BUILDING CODE OF AUSTRALIA ASSESSMENT REPORT

Crown Sydney Hotel Resort Barangaroo South, Sydney

For Crown Resorts Limited

1 Level 08
1:100

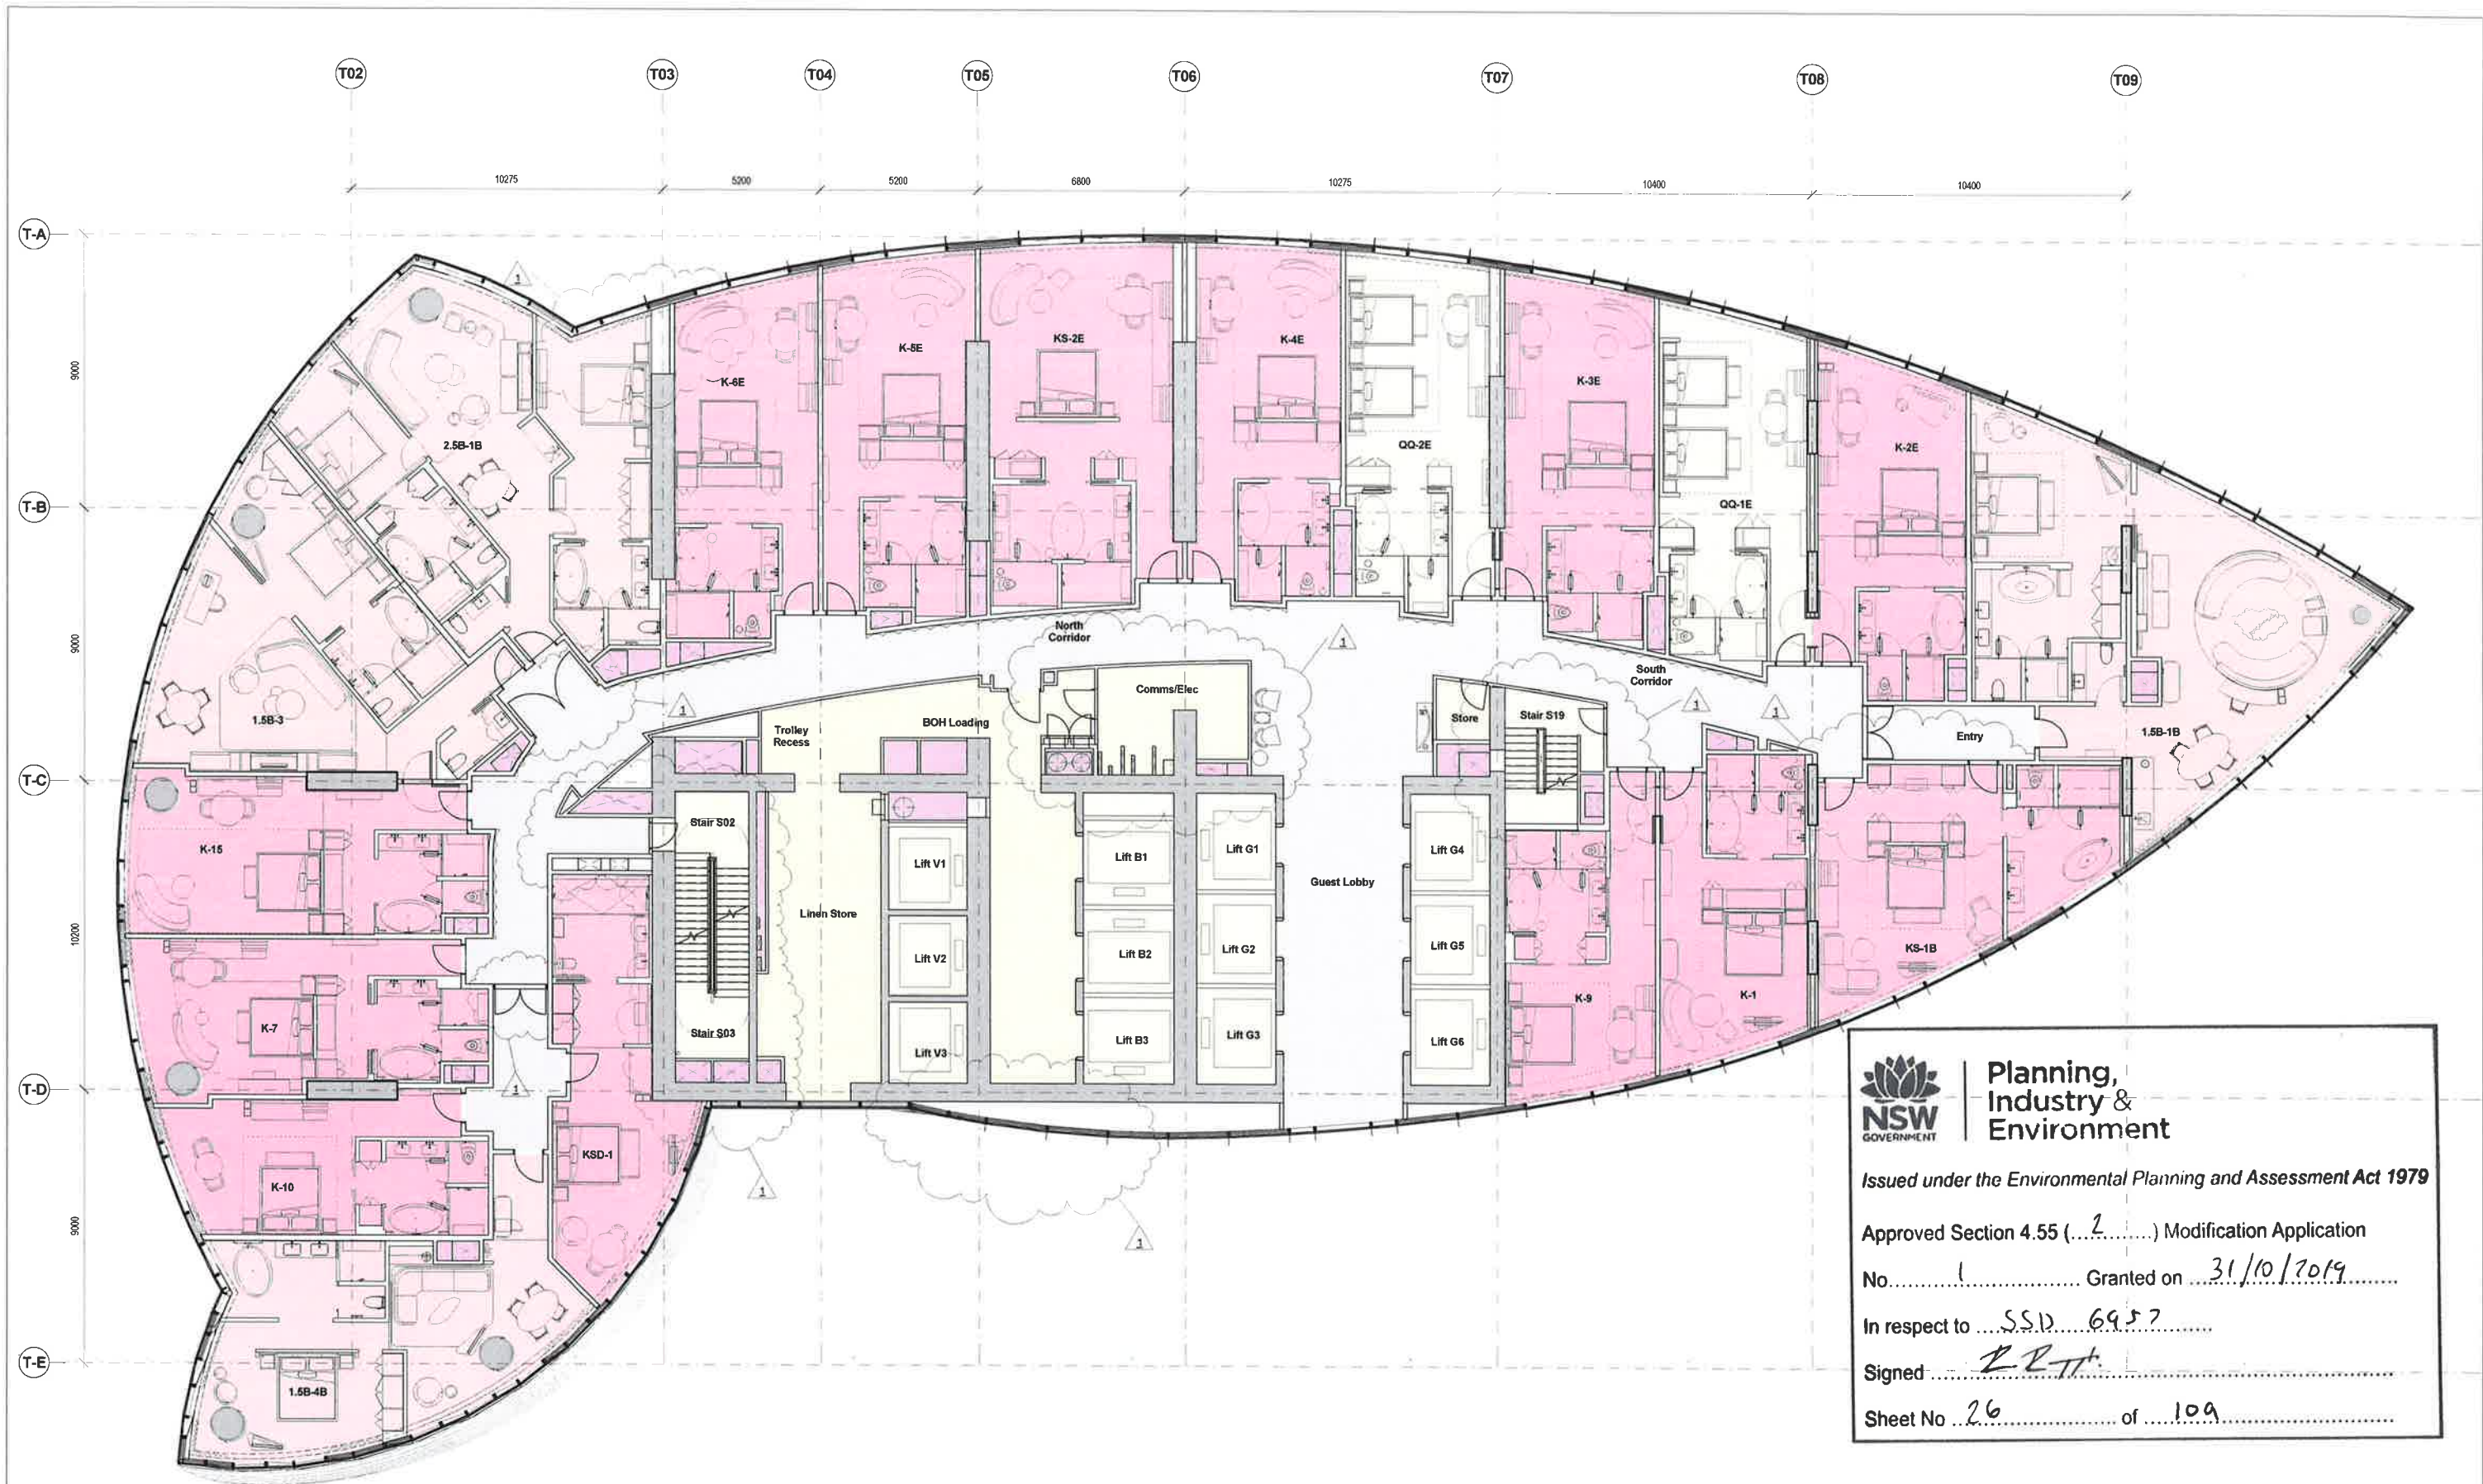
Public corridors exceeding 40m in length to be divided into intervals of not more than 40m by smoke proof walls. The corridor on hotel levels 6-22 is up to 80m with no smoke-proof construction proposed. These corridors will need to be divided into portions not exceeding 40m by smoke-proof construction with smoke doors or be addressed as part of the alternate solution. Smoke-proof construction is to comply with Specification C2.5 of the BCA.
